## Application for a Non-Material Amendment Following a Grant of Planning Permission

Erection of single storey dwelling - outline approval of H23-0970-22 (Resubmission of H23-0797-23)

H23-0225-24

PP 1000 Rev D

Job Title Proposed Dwelling Ravens Bank, Whaplode St Catherine, PE12 6SH For: S&R Properties	Date August 2023	Drawn by MC
Drawing Title Planning Drawing Floor Plans, Elevations, Site Plans & Section	Job No. SE-1985	Checked by RS
	Dwg No. PP1000	Sheet Size A1
		Revision D

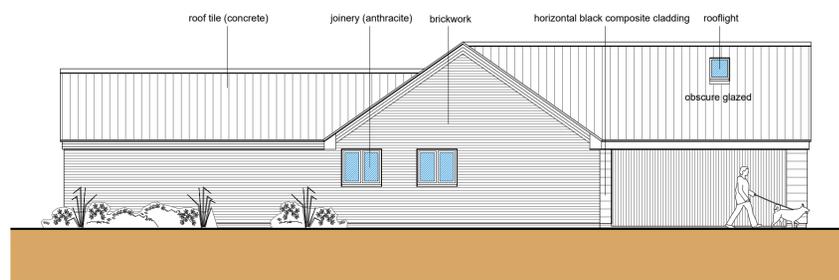
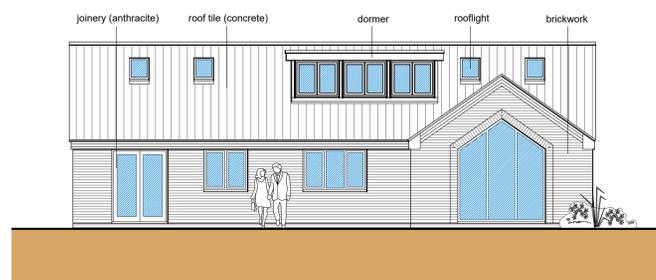
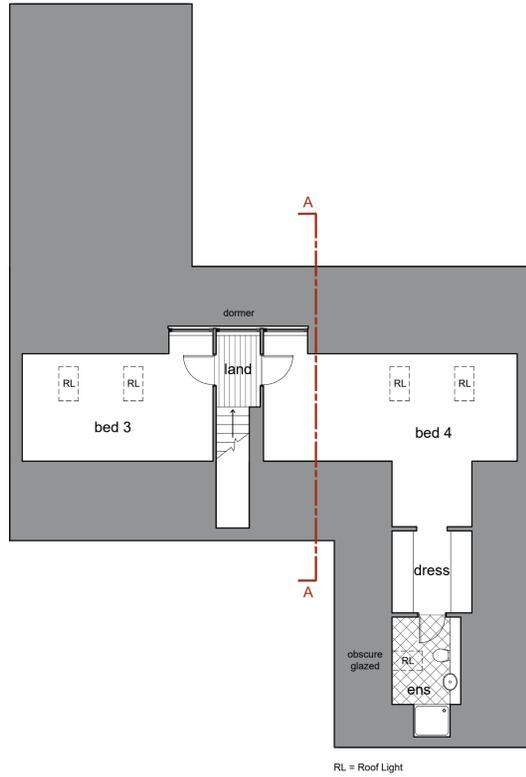
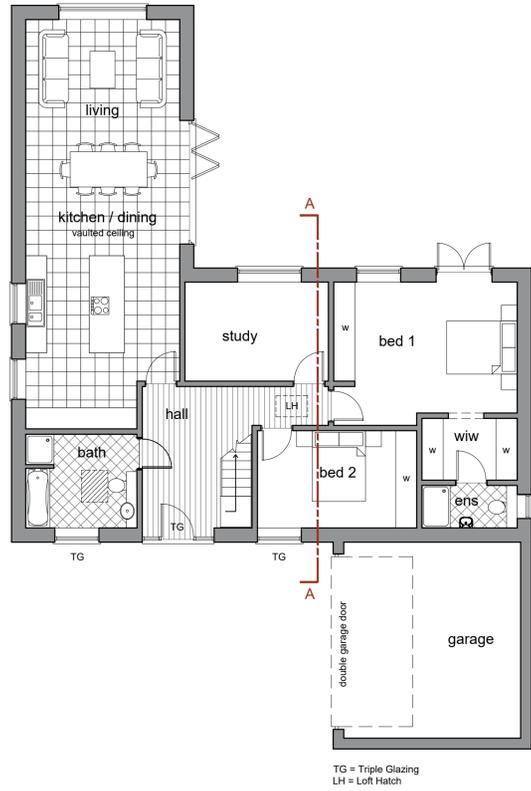
- Addition of first floor within loft space (no increase in external scale of building).
- Addition of dormer on rear elevation, facing agricultural field to the south (no overlooking to east / west).
- Addition of roof lights on rear elevation, facing agricultural field to the south (no overlooking to east / west).
- Addition of roof light on west elevation to serve ensuite, to be obscure glazed.
- Internal alterations to form staircase to first floor.
